MEMORANDUM

To: FILE
From: Caitlin Cameron
Subject: Application ID: 2014-066
Date: 6/18/2014

Comments Submitted by: Marge Schmuckal/Zoning on 6/3/2014

**BUILDING ELEVATIONS**

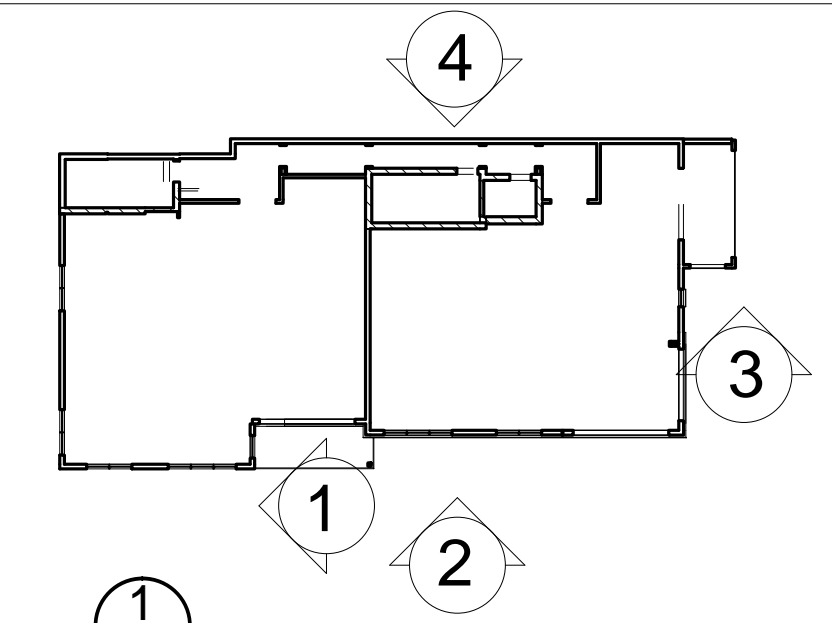
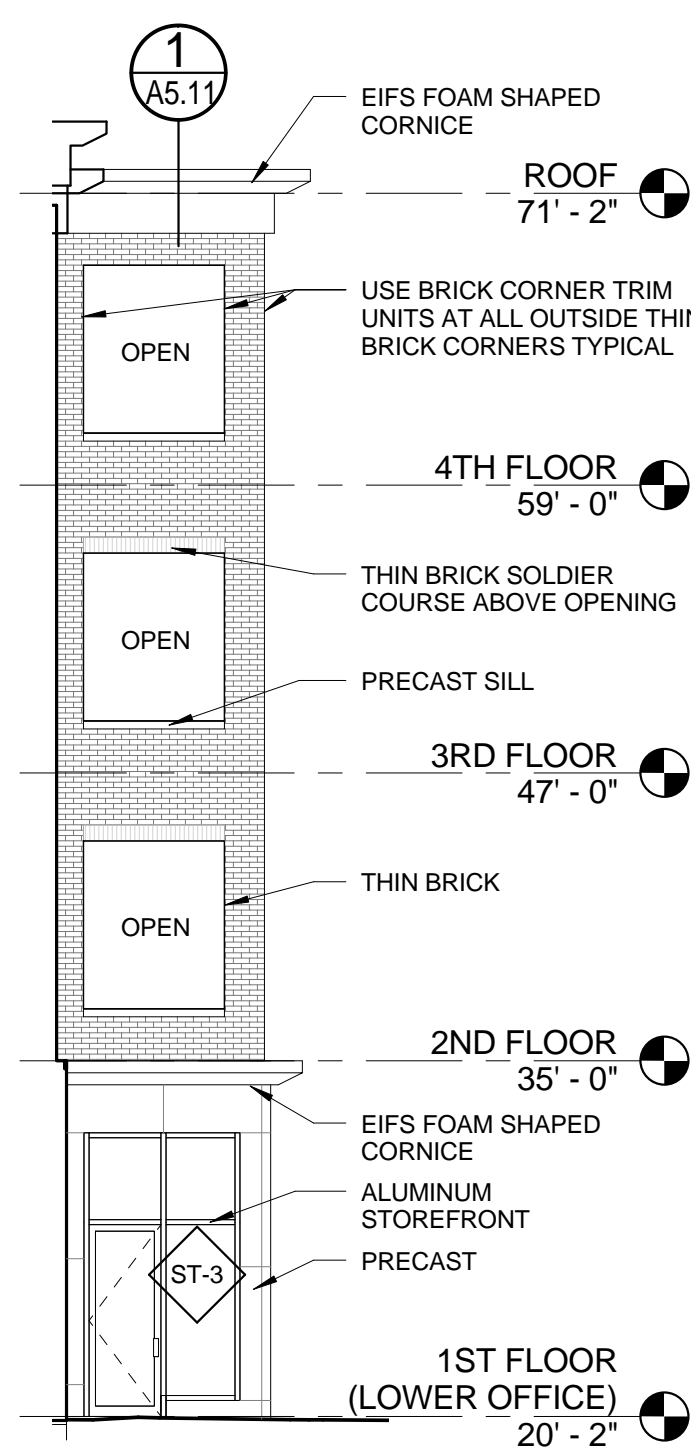
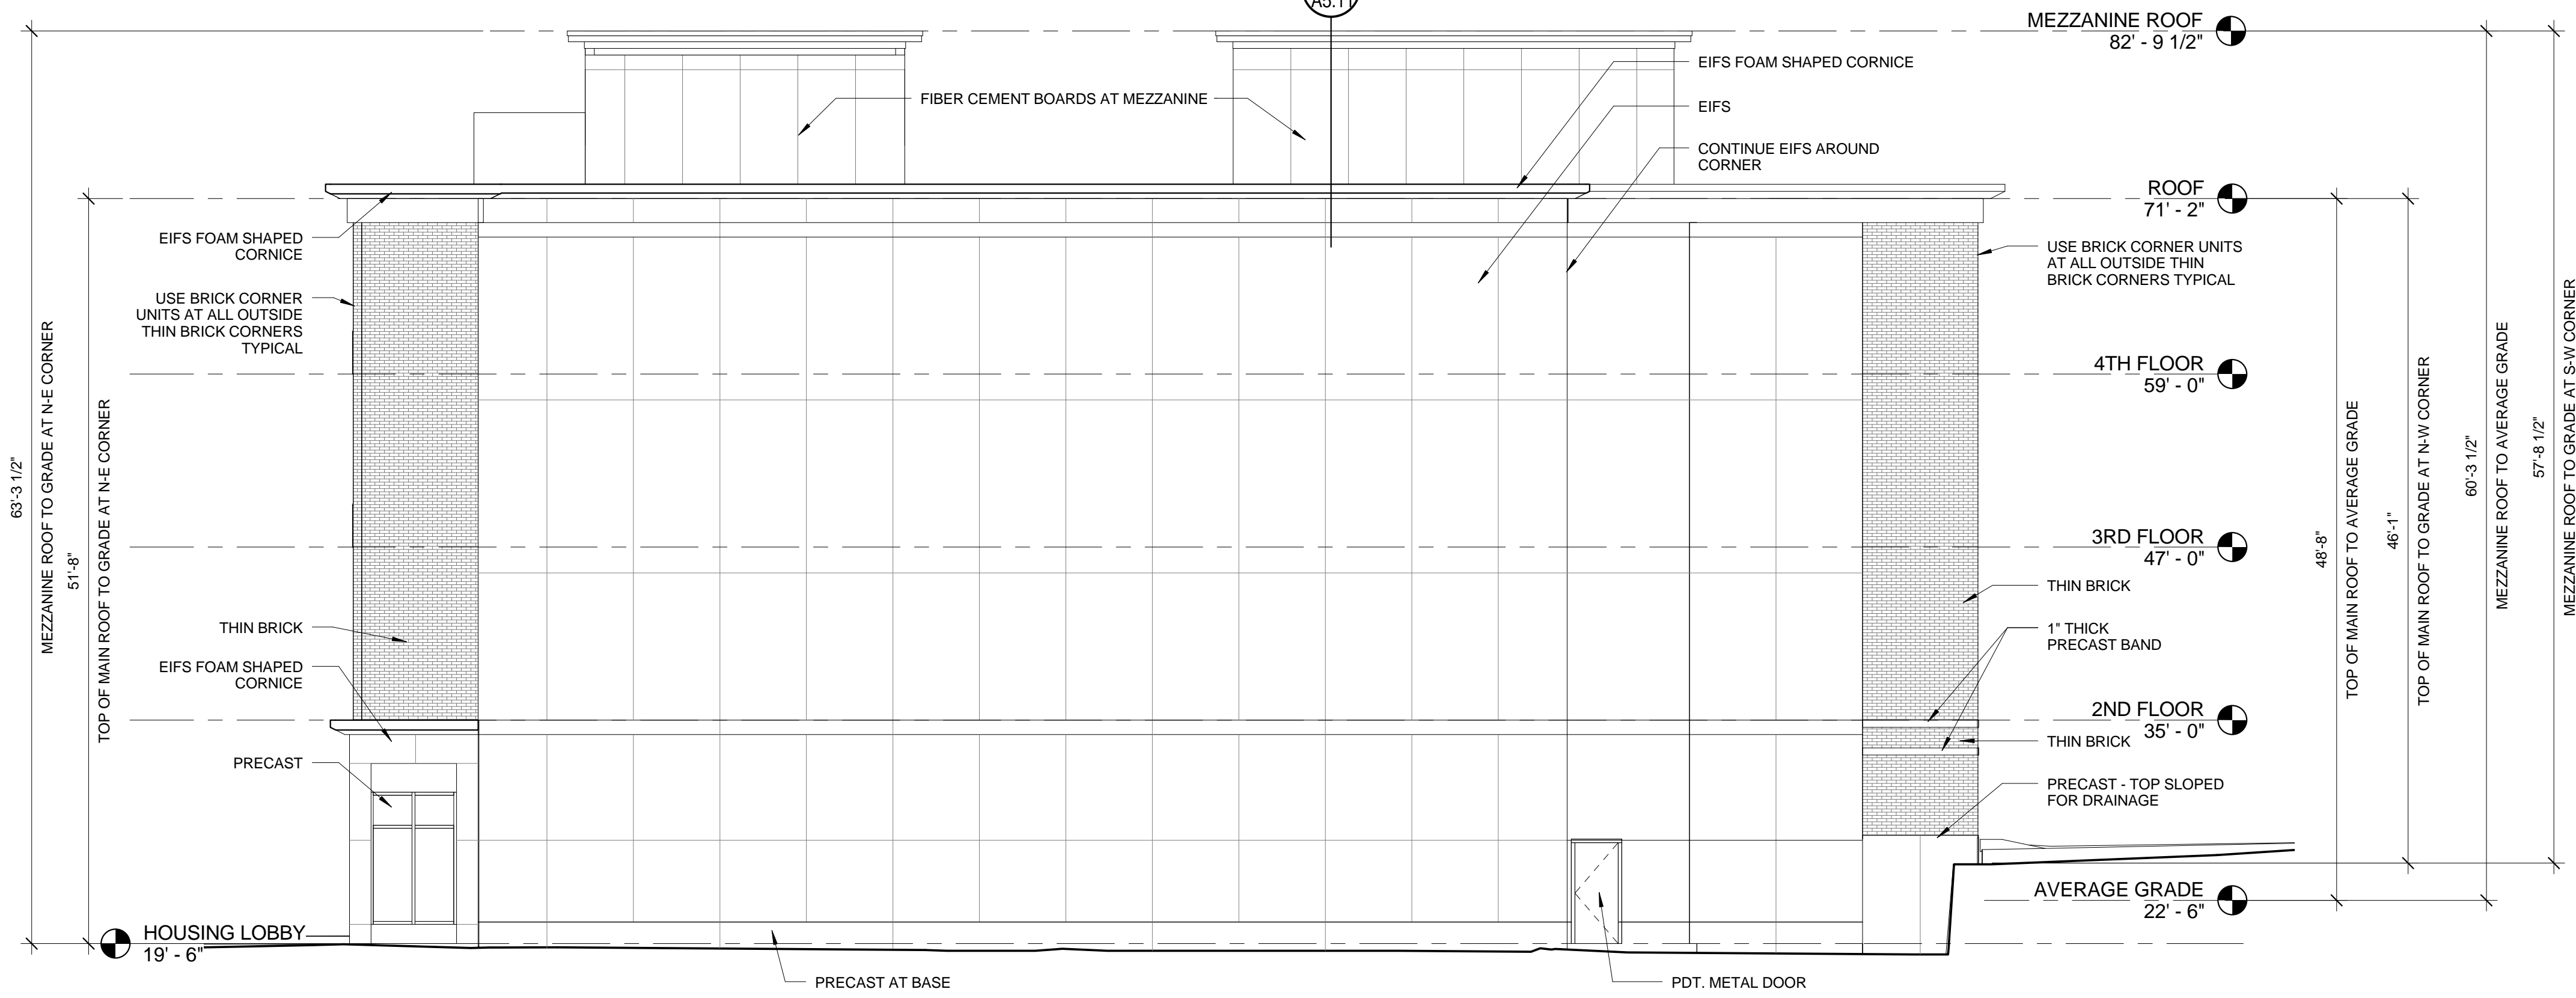
All other B-5b dimensional requirements are being met. The maximum building height is 65' and the given height is approximately 60.29 feet. The architect showed me how the average grade was determined and I accept that.
